| <b>Address</b>                 | CARPENTER'S COTTAGE, FORMER RAF UXBRIDGE, ST ANDREWS PARK HILLINGDON ROAD UXBRIDGE                                                                                                                                                                                                                                                                                                              |                                 |
| <b>Development:</b>            | Demolition and replacement of roof structure (1.0 m higher eaves and ridge level), refurbishment and restoration of building including replacement windows and doors, to aid conversion of building to a single family dwelling house (Listed Building Application)                                                                                                                             |                                 |
| <b>LBH Ref Nos:</b>            | <b>585/APP/2020/2891</b>

PROPOSED
STREET SCENE - FRONT ELEVATION

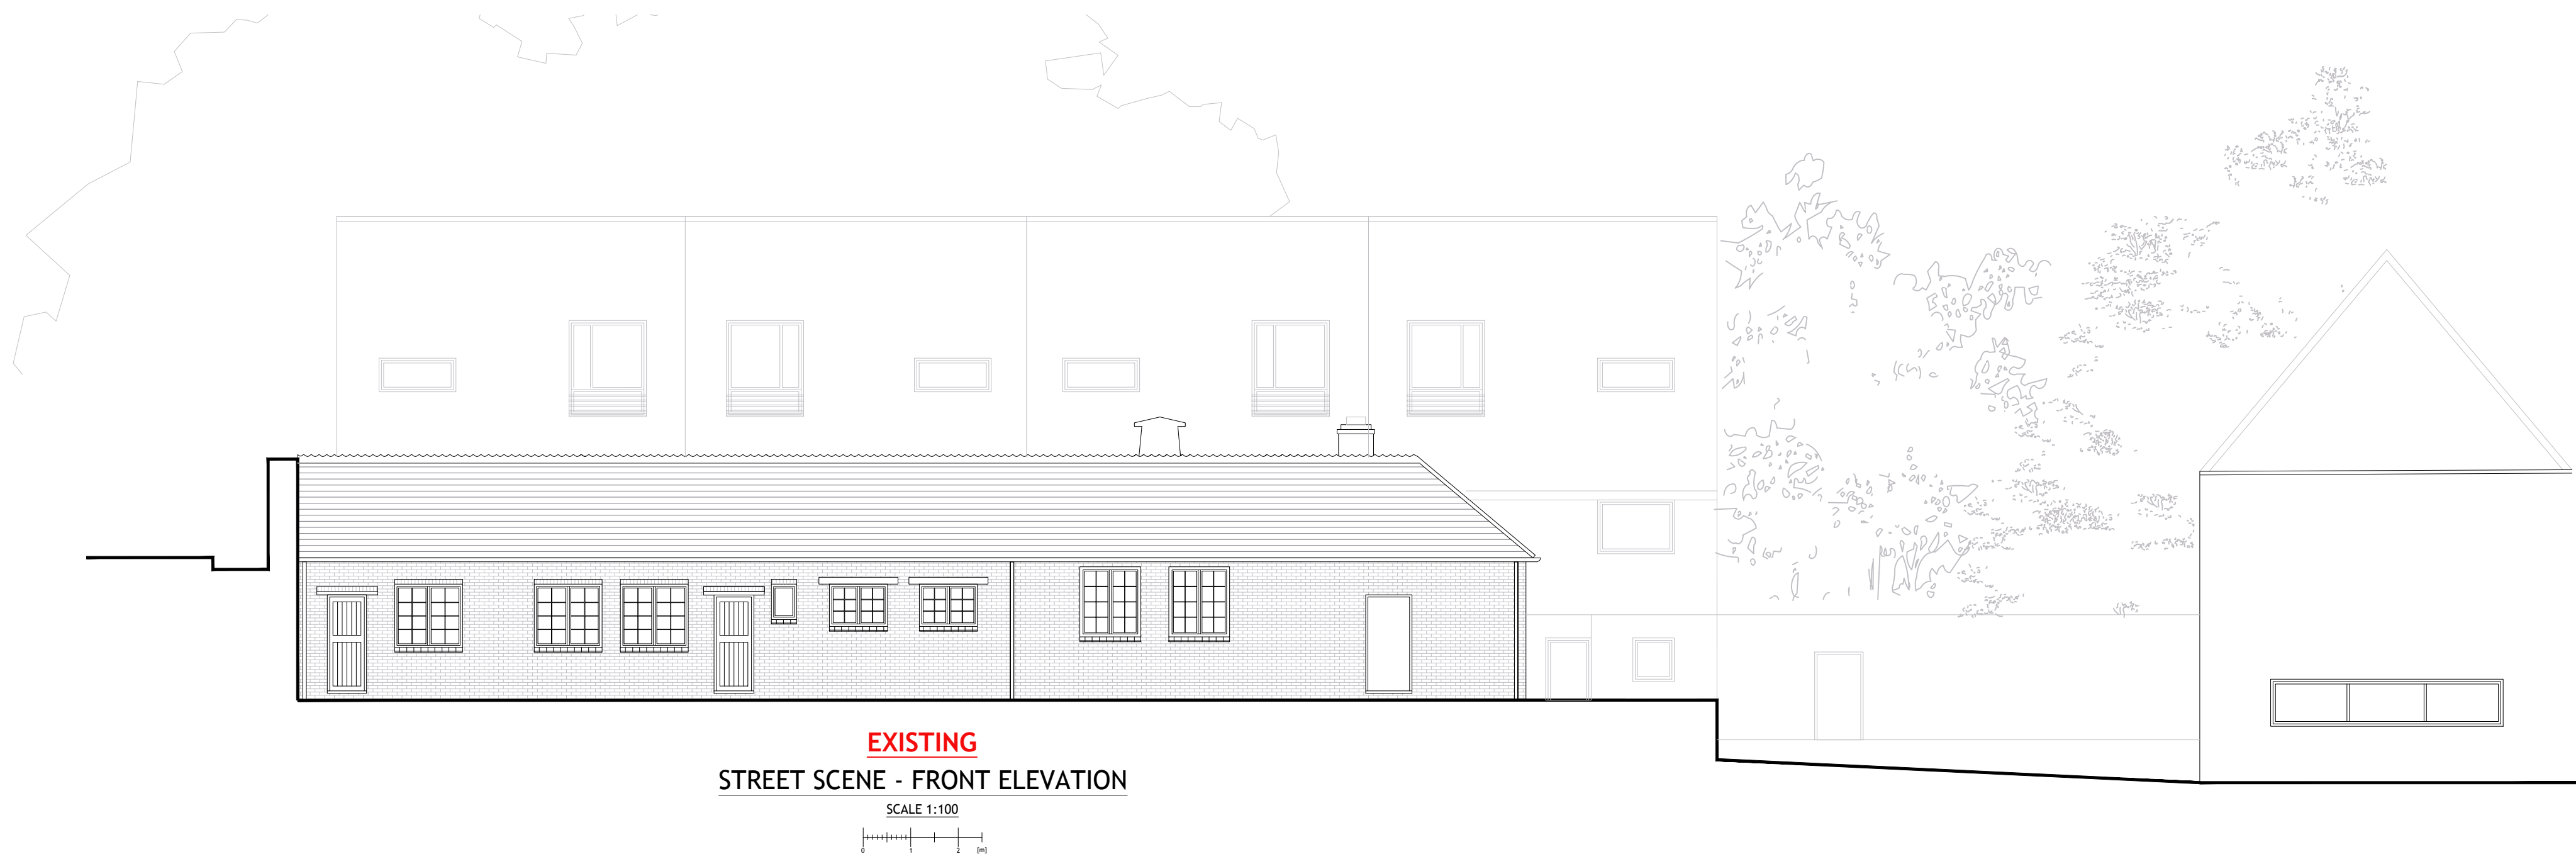
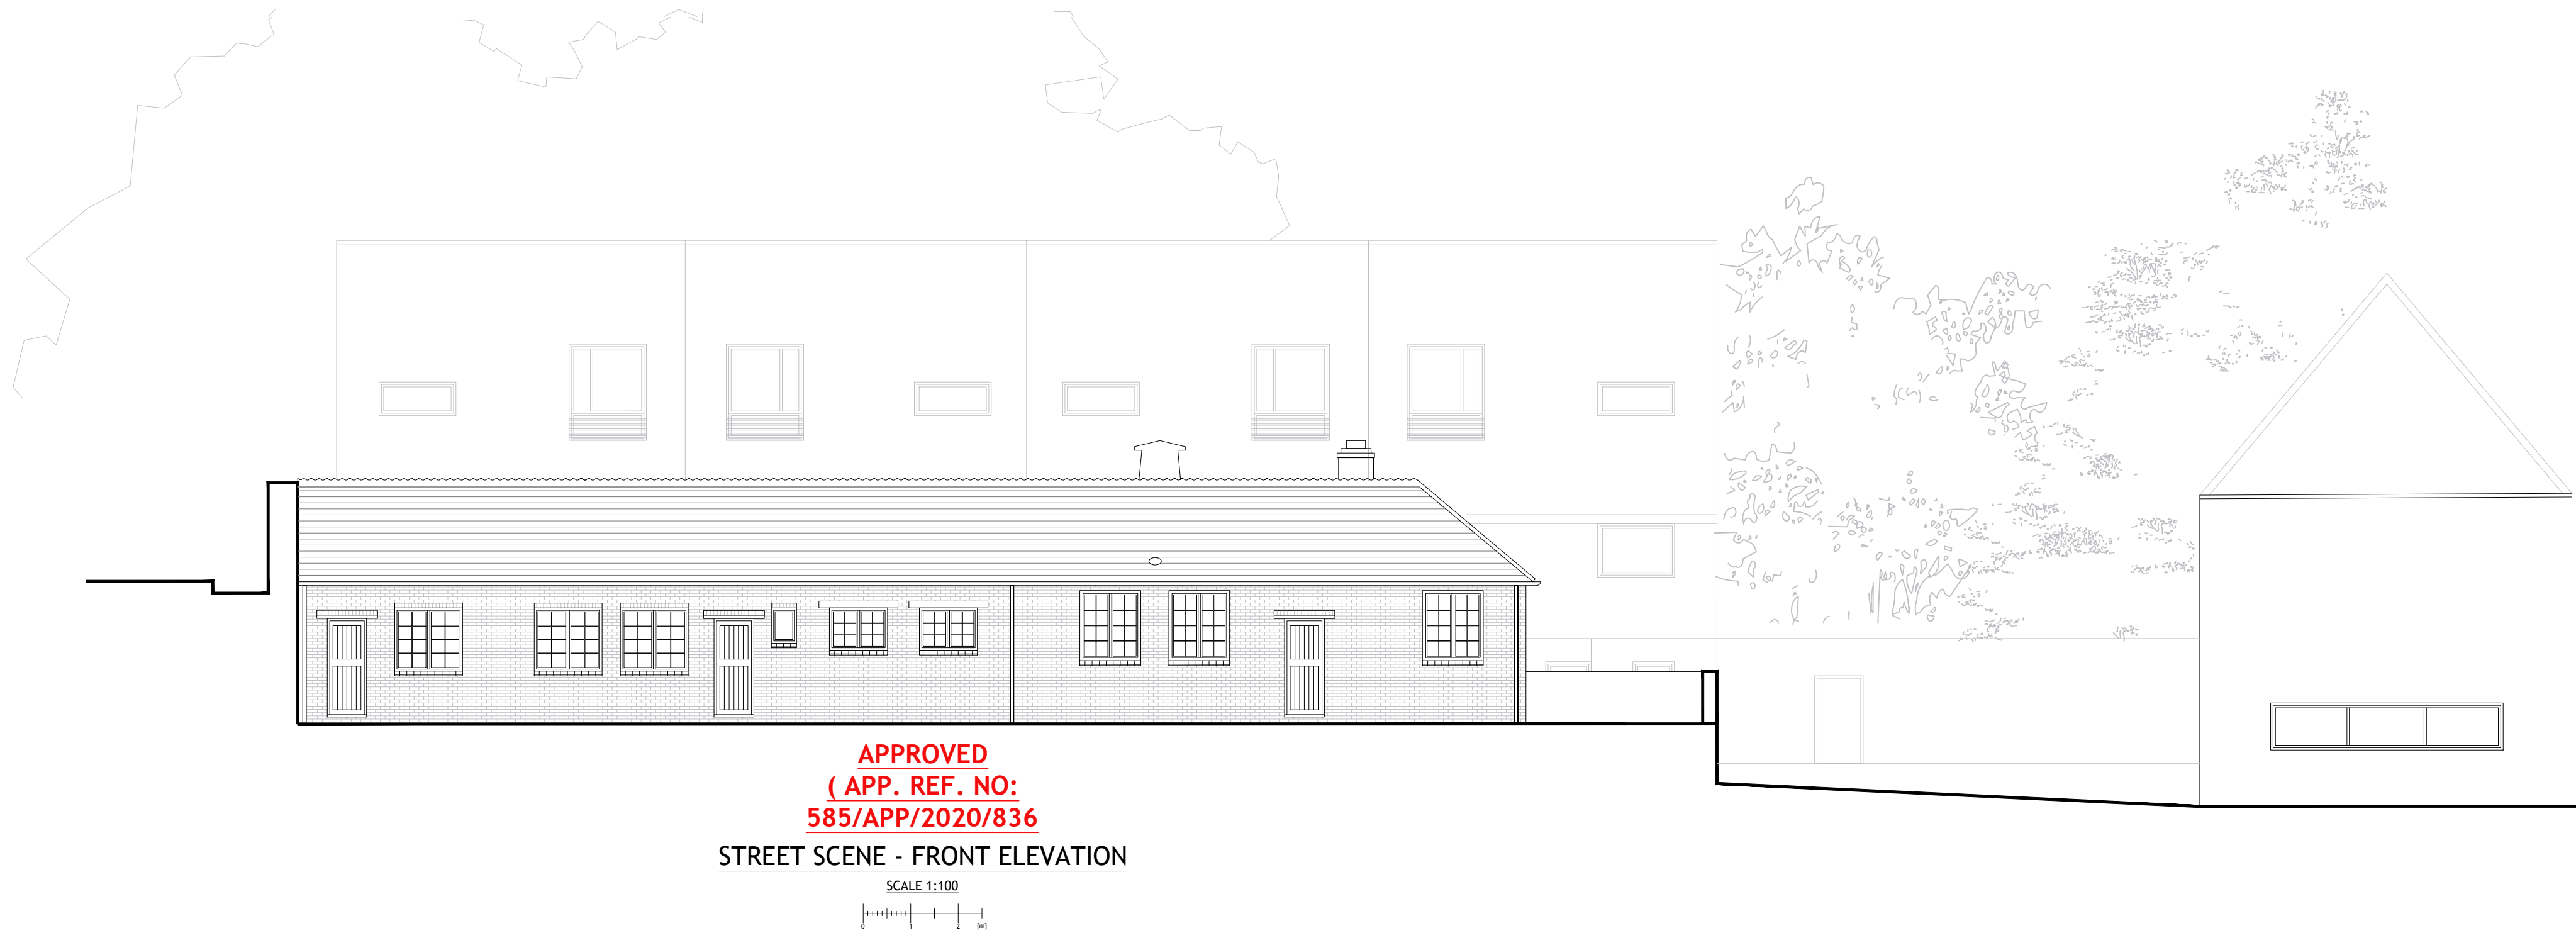
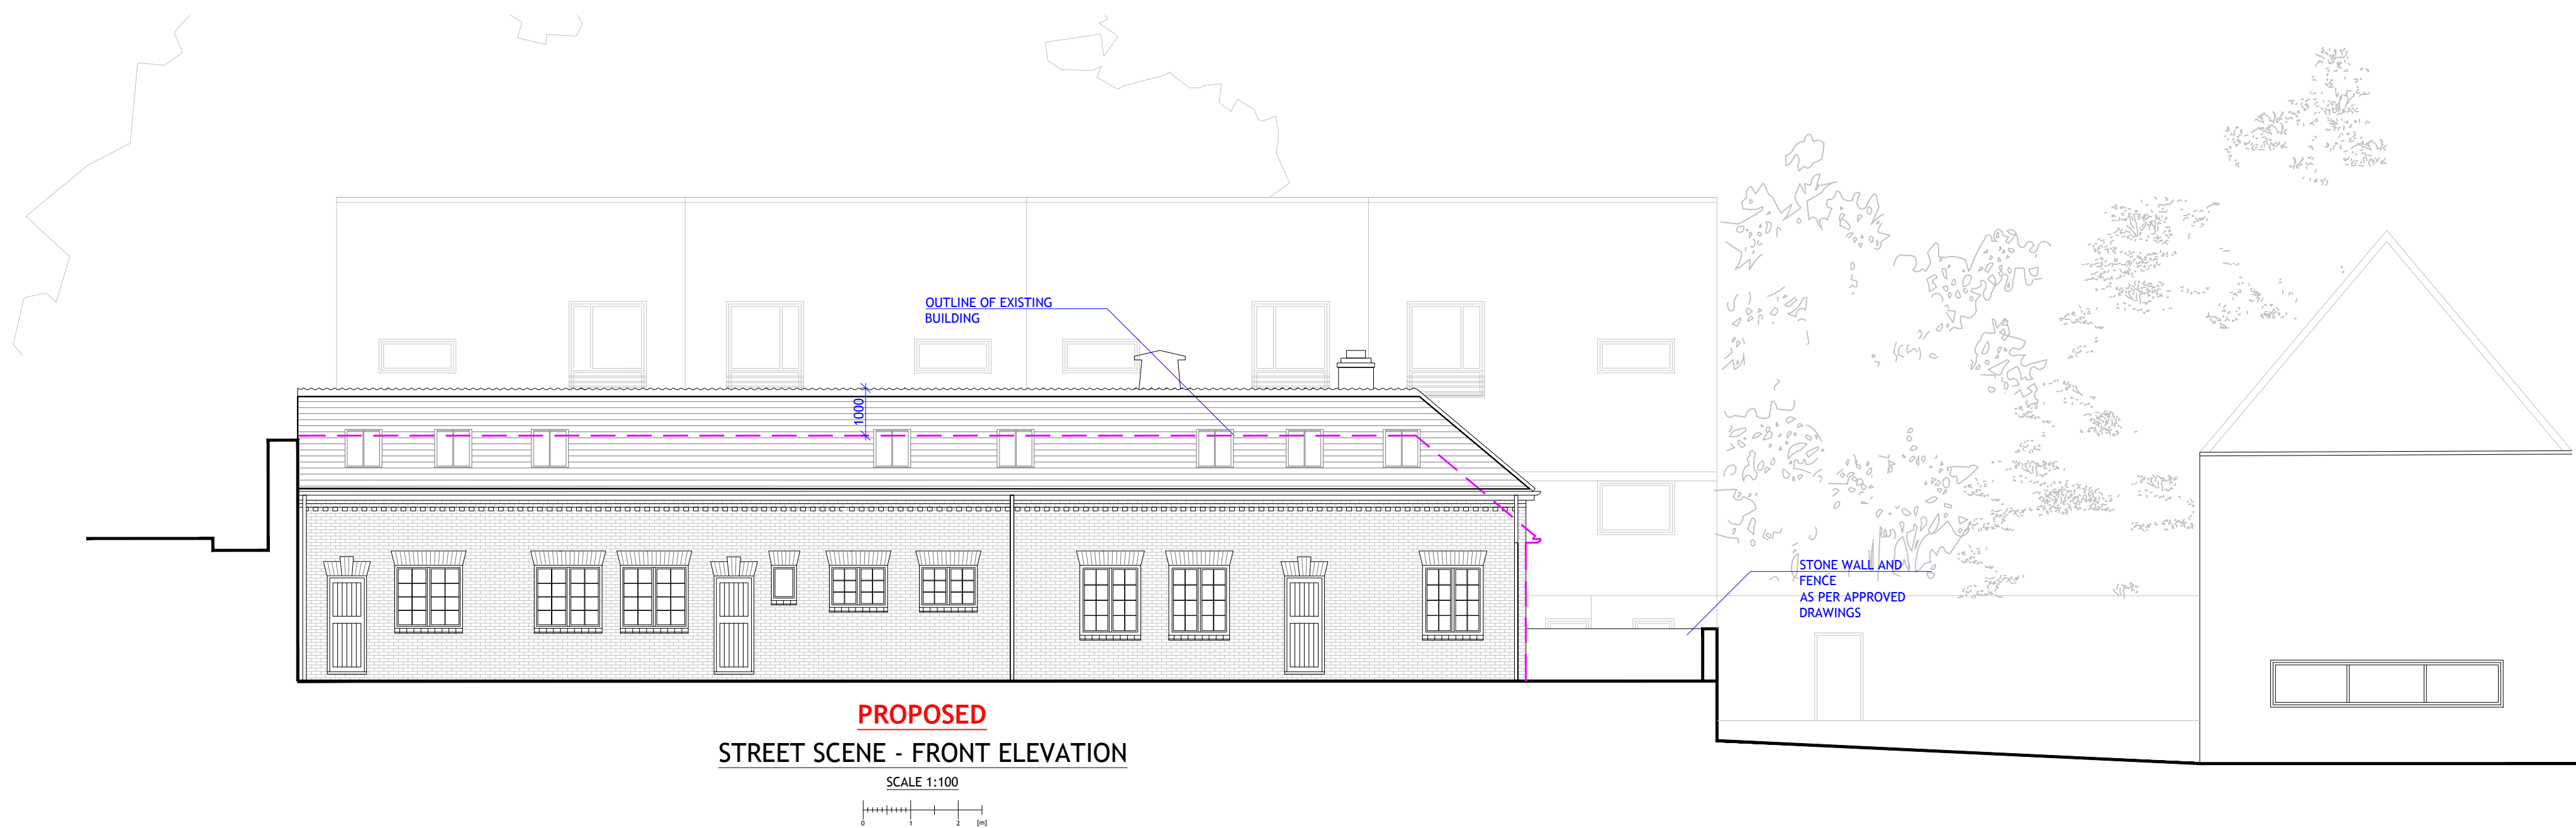
It is recognised that the building would benefit from restoration works and structural improvements, particularly to the roof. However, the proposal to raise the height of the building by at least 1m lacks any justification and would be considered significantly harmful to the designated heritage asset. The original principle of removing the existing roof structure was deemed admissible due to its current poor condition. It was agreed upon the premise that it would be reinstated to match the existing, ensuring the preservation of the building in its original built form.

The proposed clutter of roof lights to all the sloped elevations would be unacceptable. The excessive number and poor placement would result in a messy appearance to the building. The addition of the roof lights would fail to respect the simple character and appearance of the former service building.

The inclusion of a dentil cornice detail along the roof eaves and brick headers above the windows would introduce inappropriate decorative features to the building. Considering the status of the structure as an ancillary service building, it would detract from its simple nature. In this instance it would be deemed unacceptable.
